WEST SUSSEX COUNTY COUNCIL CONSULTATION

TO:	Arun District Council FAO:A Gardner
FROM:	WSCC - Highways Authority
DATE:	27 January 2021
LOCATION:	Ham Manor Cottage Ham Manor Way Angmering BN16 4JQ
SUBJECT:	A/193/20/PL Erection of a 1 No. 3 bedroom chalet bungalow & detached garage. This site is in CiL Zone 3 and is CIL Liable as dwelling.
DATE OF SITE VISIT:	n/a
RECOMMENDATION:	Advice
S106 CONTRIBUTION TOTAL:	n/a

Revision:	A	Dec 2020	Dimension added
address	Ham Manor Cottage, Ham Manor Way, Worthing, West Sussex		
project	Proposed construction of 3 bedroom detached property with detached double garage		
title	Proposed Block Plan		
scale	date	dwg no.	revision
1:200 on A4		2020.275.02	A

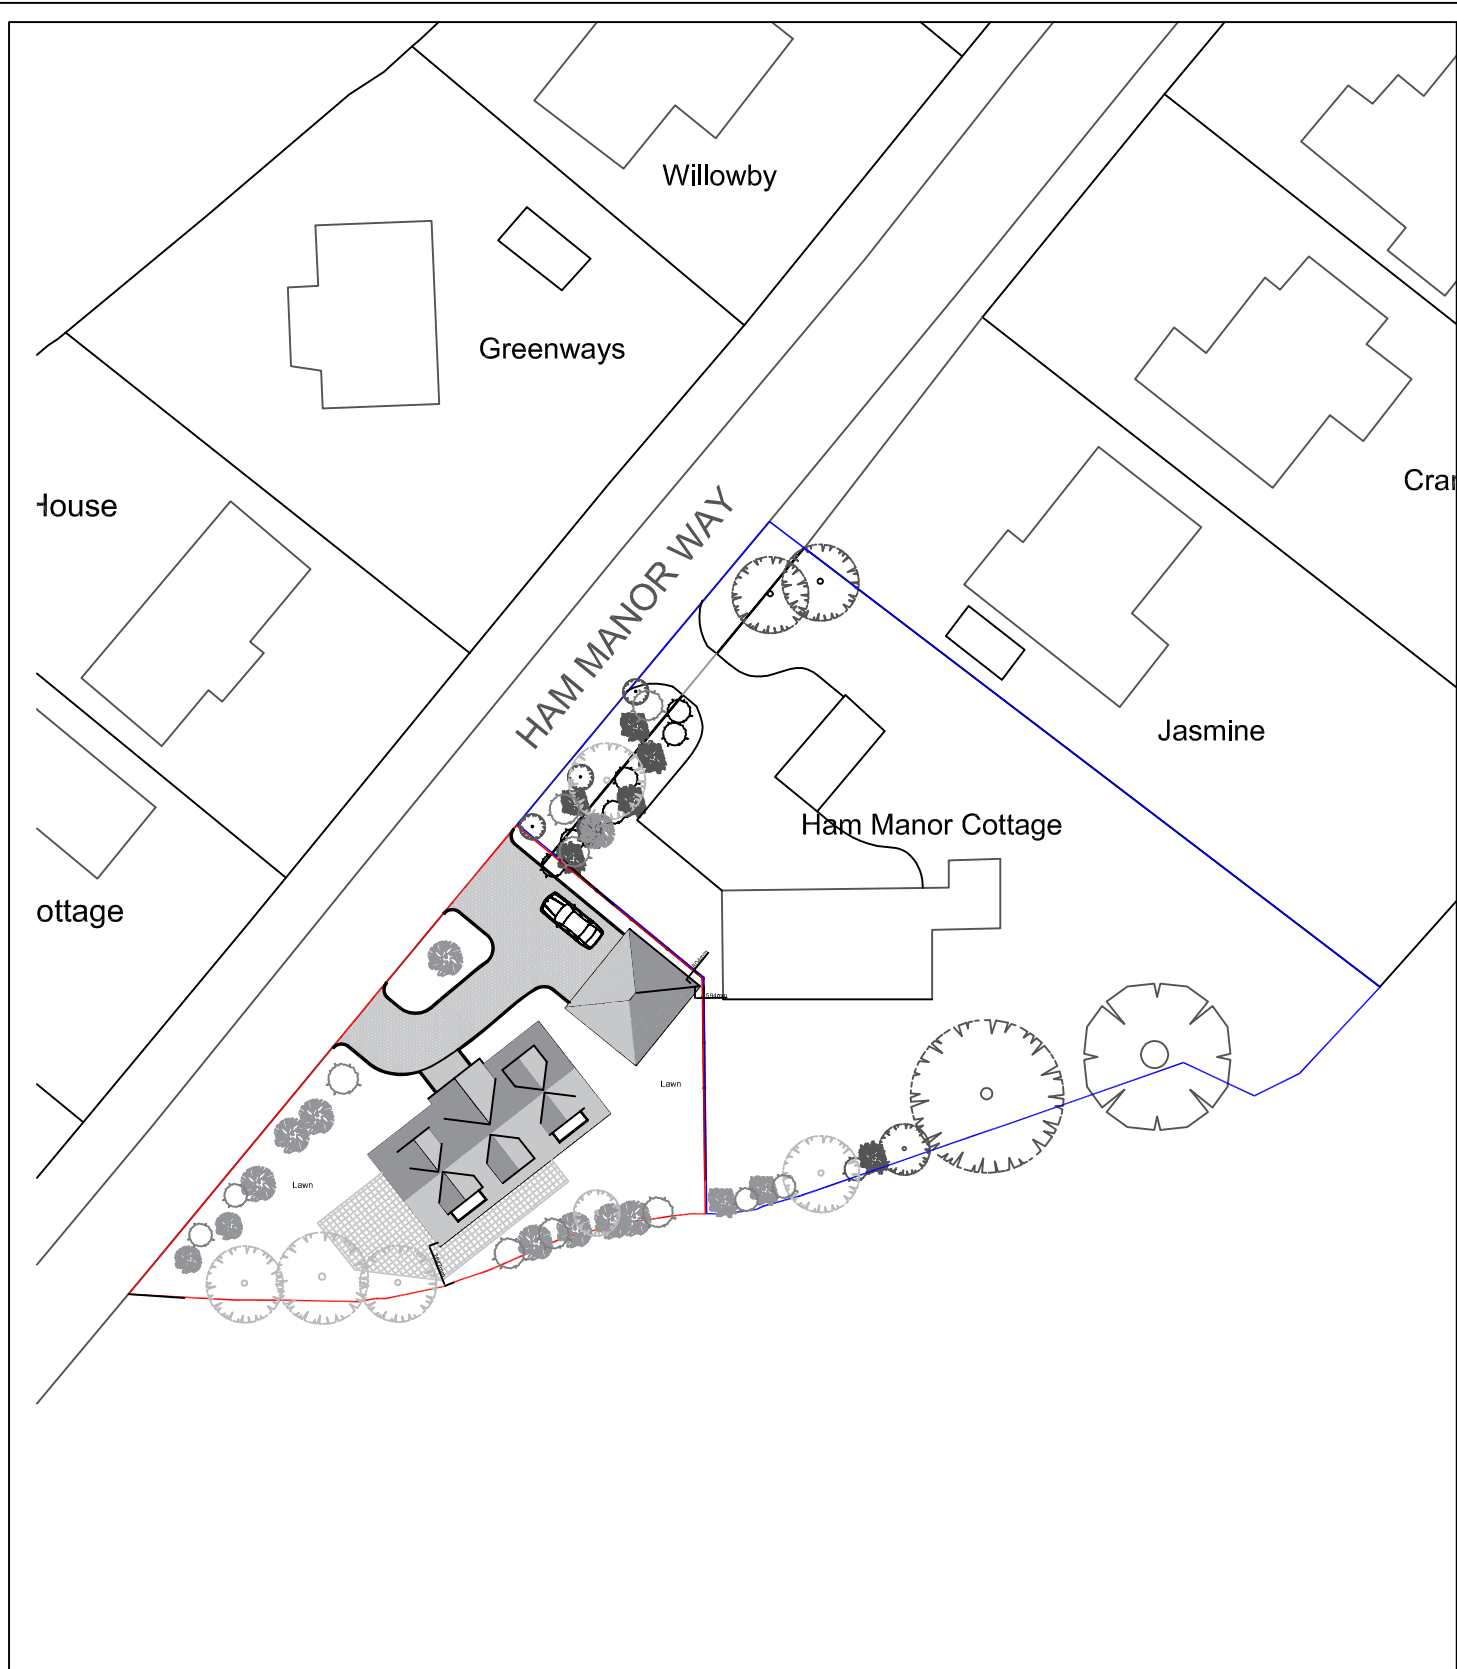
The proposed garage measures circa 5.8 x 5m which would be insufficient to accommodate two vehicles considering the Manual for streets requirements of 6 x 6m for a double garage, therefore it would not be counted towards the parking provision. The applicant may wish to consider modifying the garage to meet the current WSCC standards for a double garage.

The revised WSCC Car Parking Demand (PDC) Calculator would expect at least 3 spaces to be provided for 3-bedroom dwelling in this location. The block plan appears to be scaled incorrectly; however it may be possible to accommodate the expected provision. The LHA would not anticipate any highway safety concern in this location, however the LPA may wish to assess any implications on-street parking from an amenity perspective.
